# CITY OF ALBUQUE

August 9, 2021  
Scott McGee PE  
9700 Sand Verbena Trail, NE  
Albuquerque, NM 87122

**Re: Element Hotel - 2440 Louisiana Blvd., NE  
Erosion and Sediment Control Plan  
Engineer's Stamp Date 6/25/21 (H19E087)**

ELEMENT HOTEL
2440 LOUISIANA BLVD NE

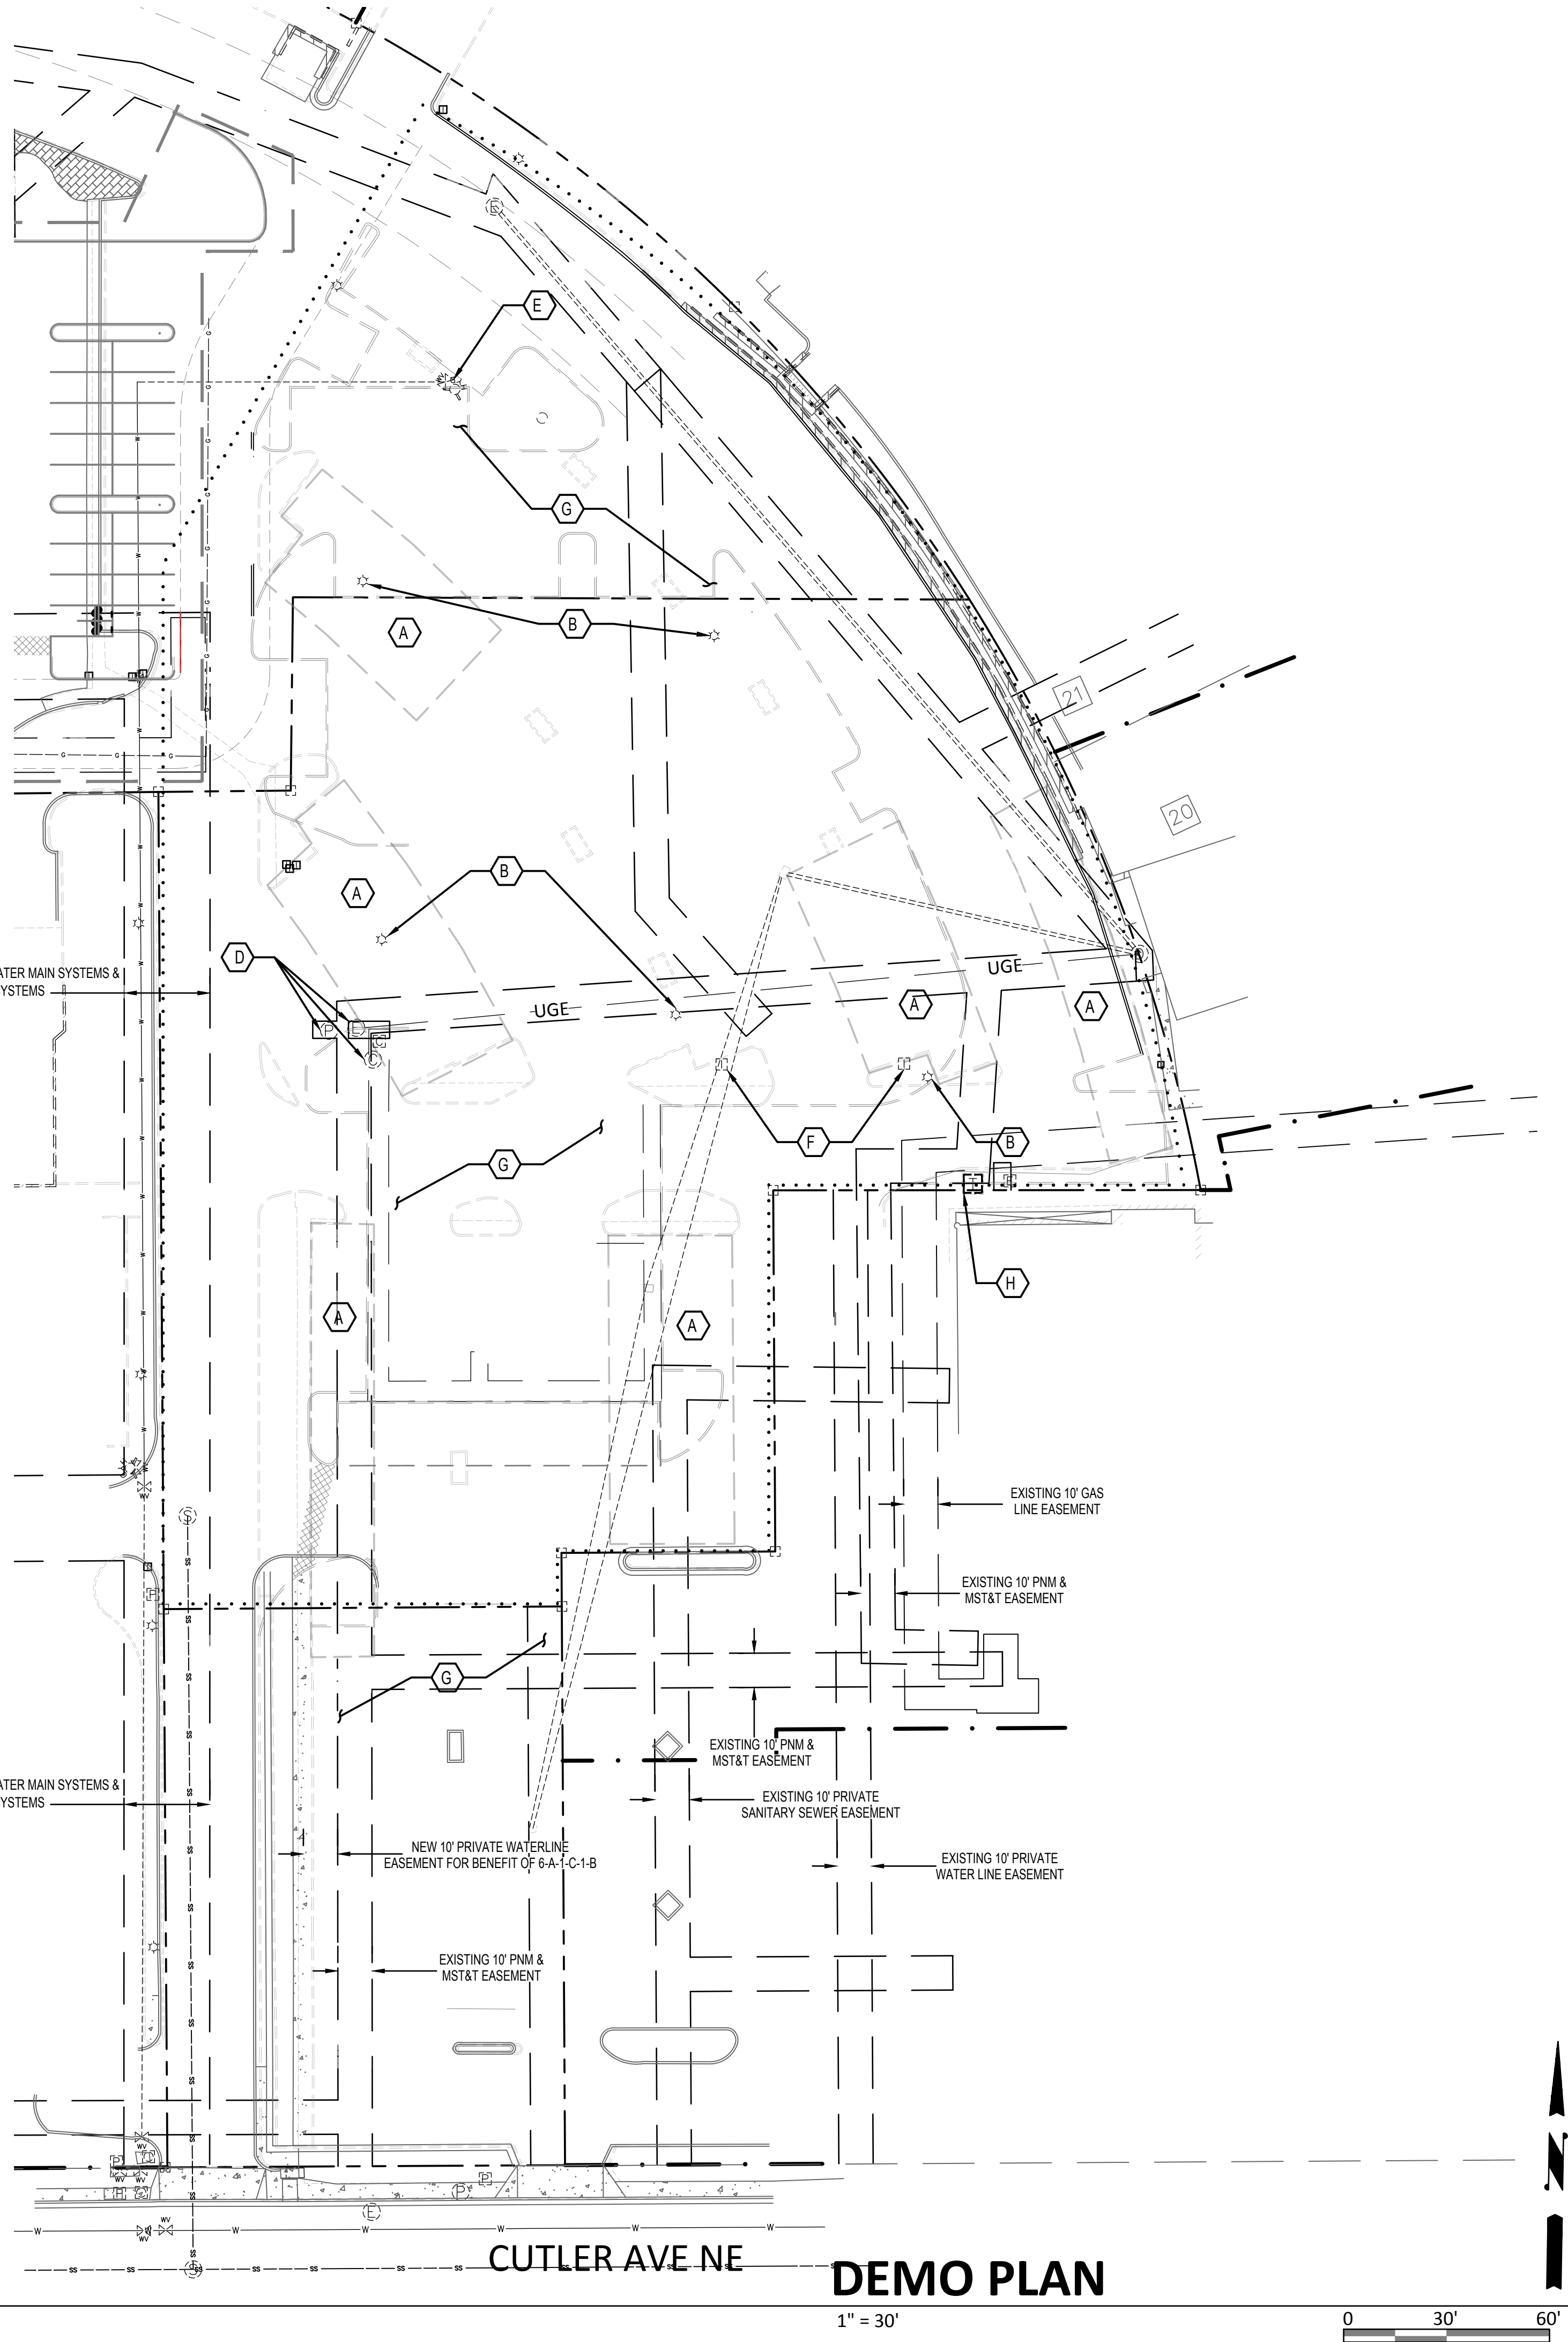
5. Show the Limits of Land Disturbing activities on the ESC Plan and provide a demolition plan on a map of existing conditions showing all of the impervious surfaces to be removed.

ESC PLAN

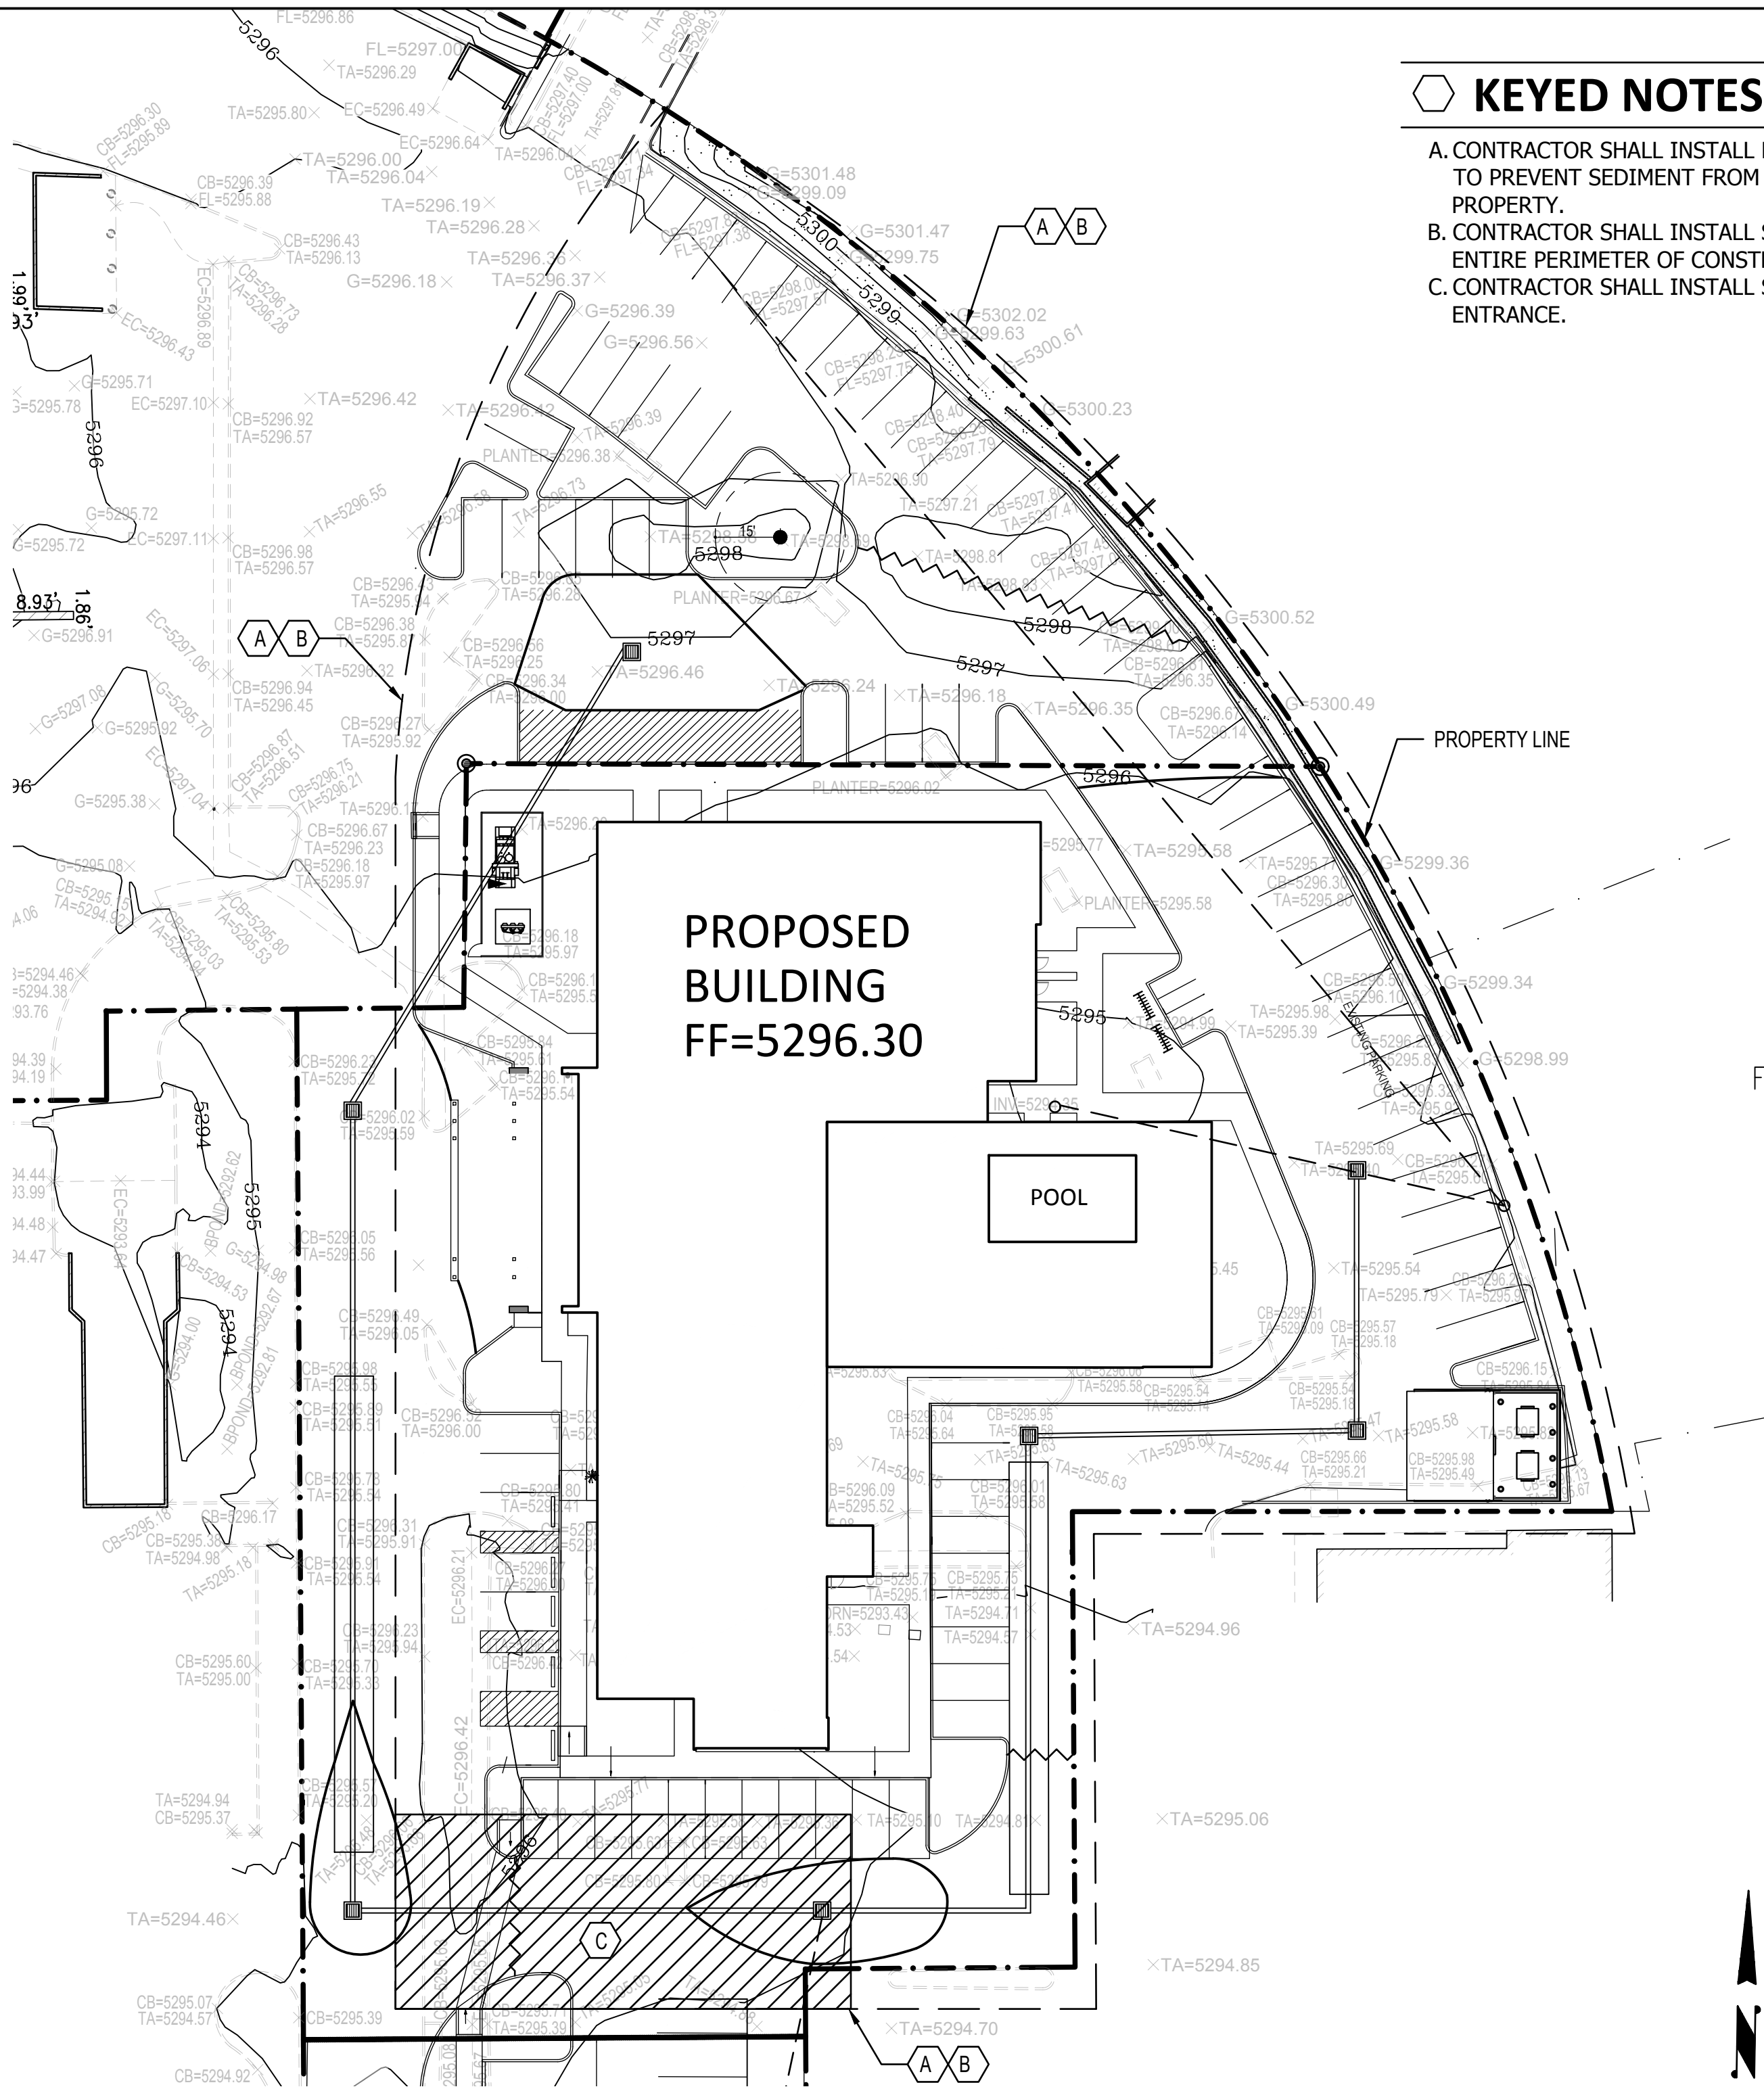
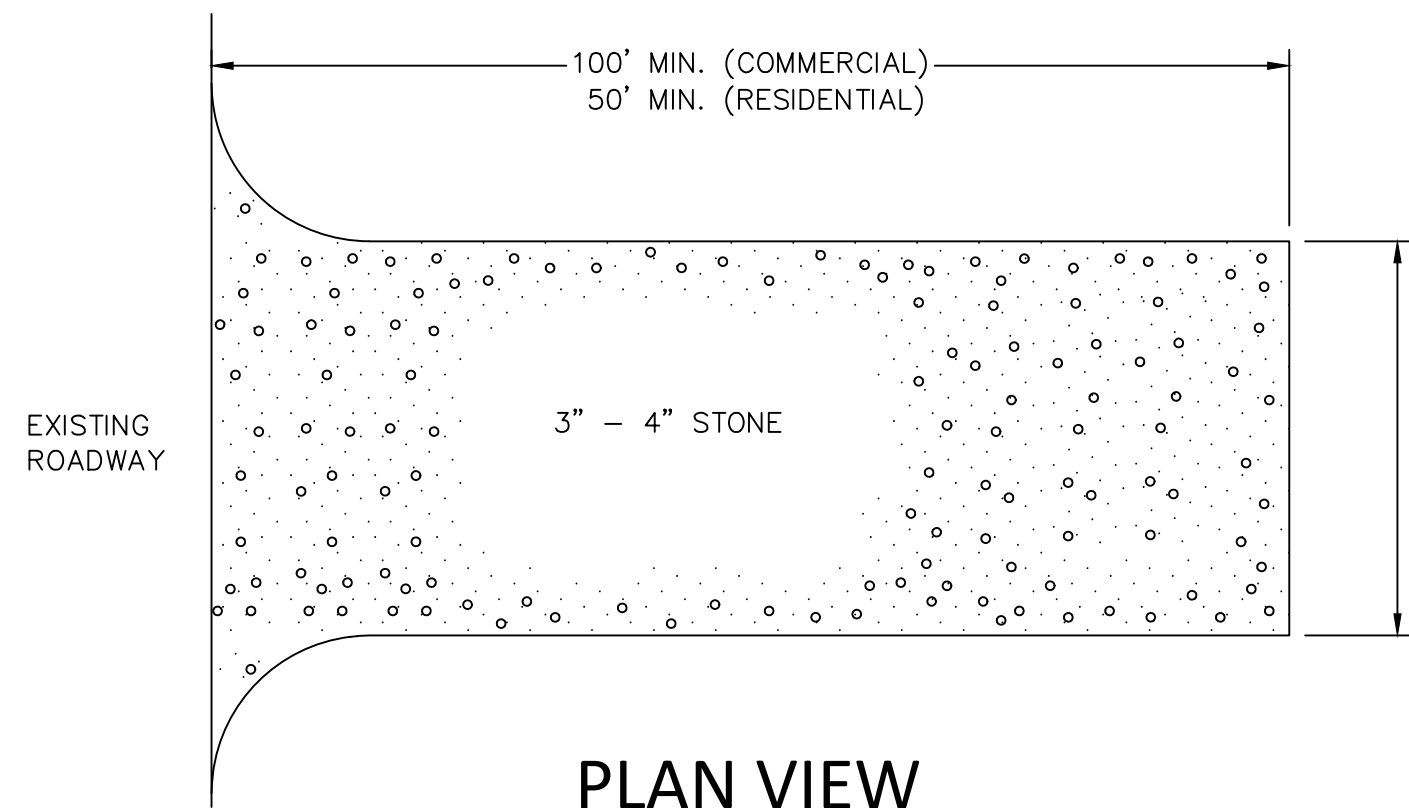
1. I can't tell the difference between building, sidewalk, asphalt and dirt on the ESC Plan. These structures must be clearly identified in the SWPPP per CGP 7.2.4.b.v. The same information is required in the ESC Application. You may include a copy of the Site Plan in both the SWPPP and in the ESC Application to address this requirement.

3. Everyone who qualifies to be an operator must file an NOI and obtain permit coverage. These operators should be identified on the ESC Plan with contact information for each.

7. Update the engineer's stamp date each time the plan is changed.
8. Update the City Standard Notes (see attached).
9. Vicinity map – add a zone atlas map clearly indicating location and street names.
